I write to object to application A/176/17/PL.

Side Elevation (south-west)

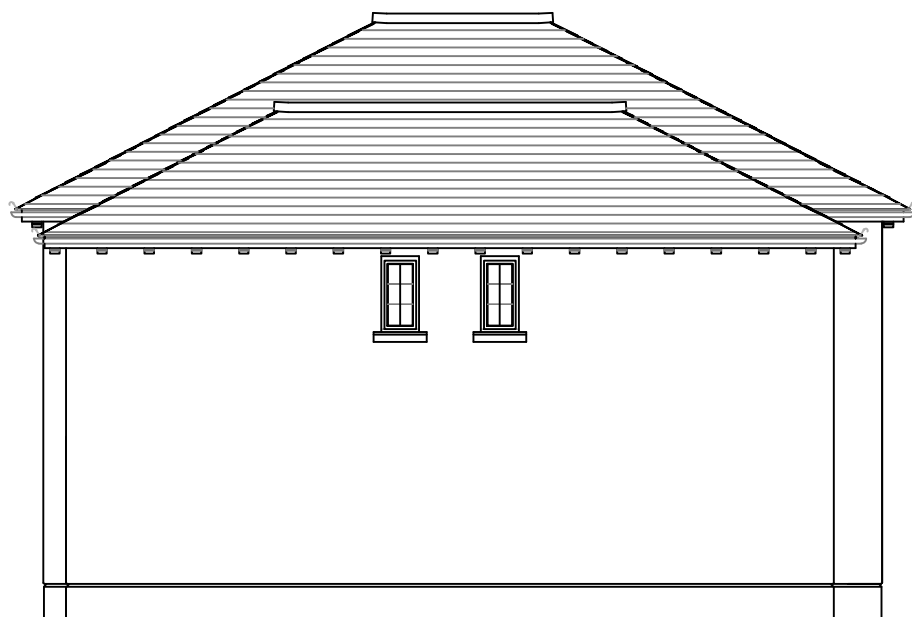
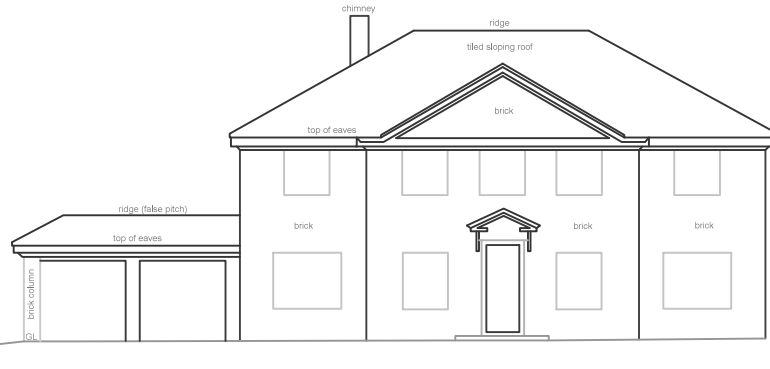
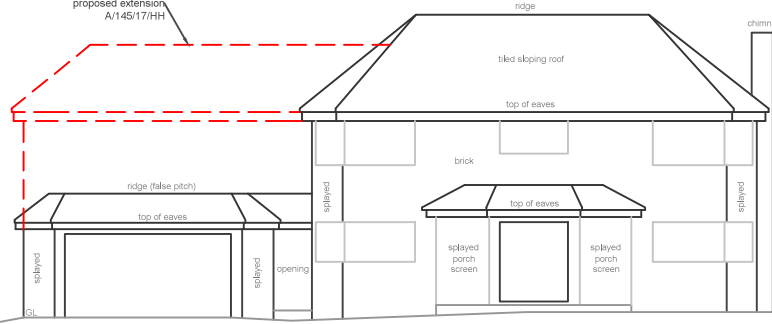
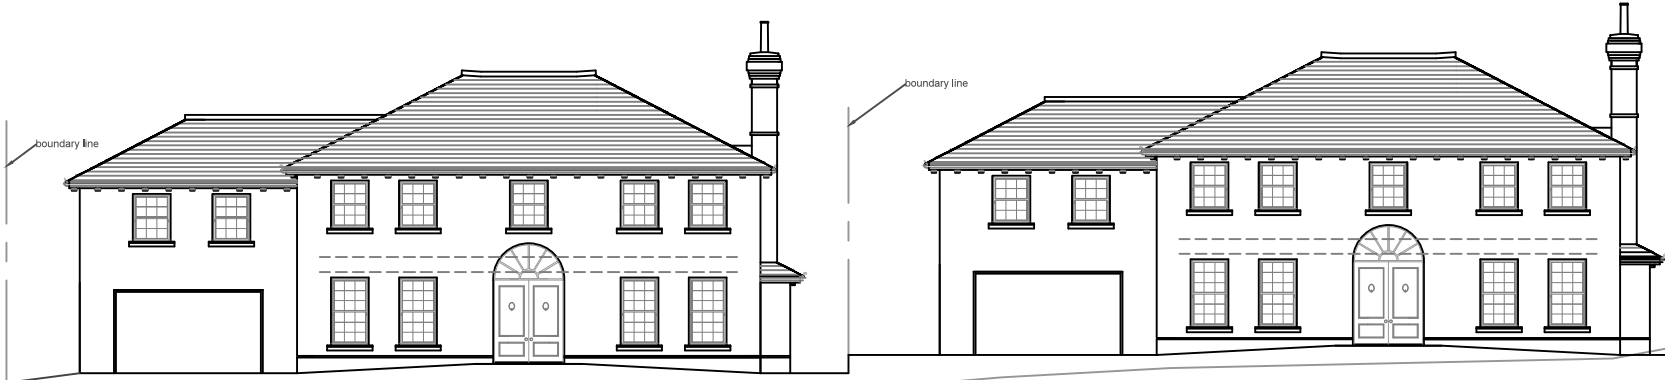
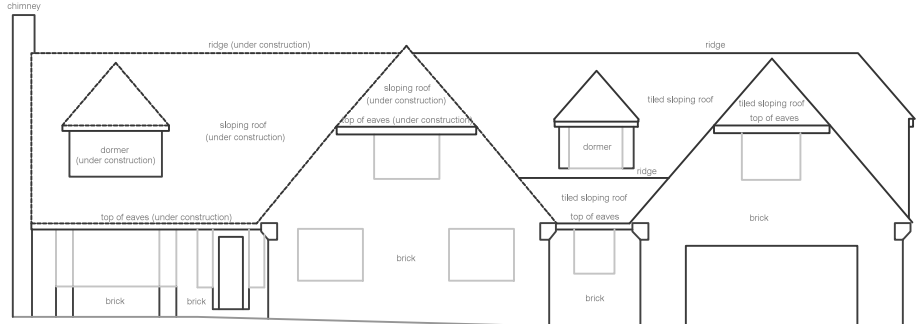
The open spaces in Ham Manor Way are of considerable beauty and any development would impact this unique land at the ninth and totally ruin the view of the protected countryside. The proposal will effect the environment and the amenities of local and neighbouring occupiers. For Angmering residents and occupiers the area in question is of community value, especially considering the thousands of people using the footpath for access and recreation and enjoyment of the Historic Parkland which will be lost to all if developed.
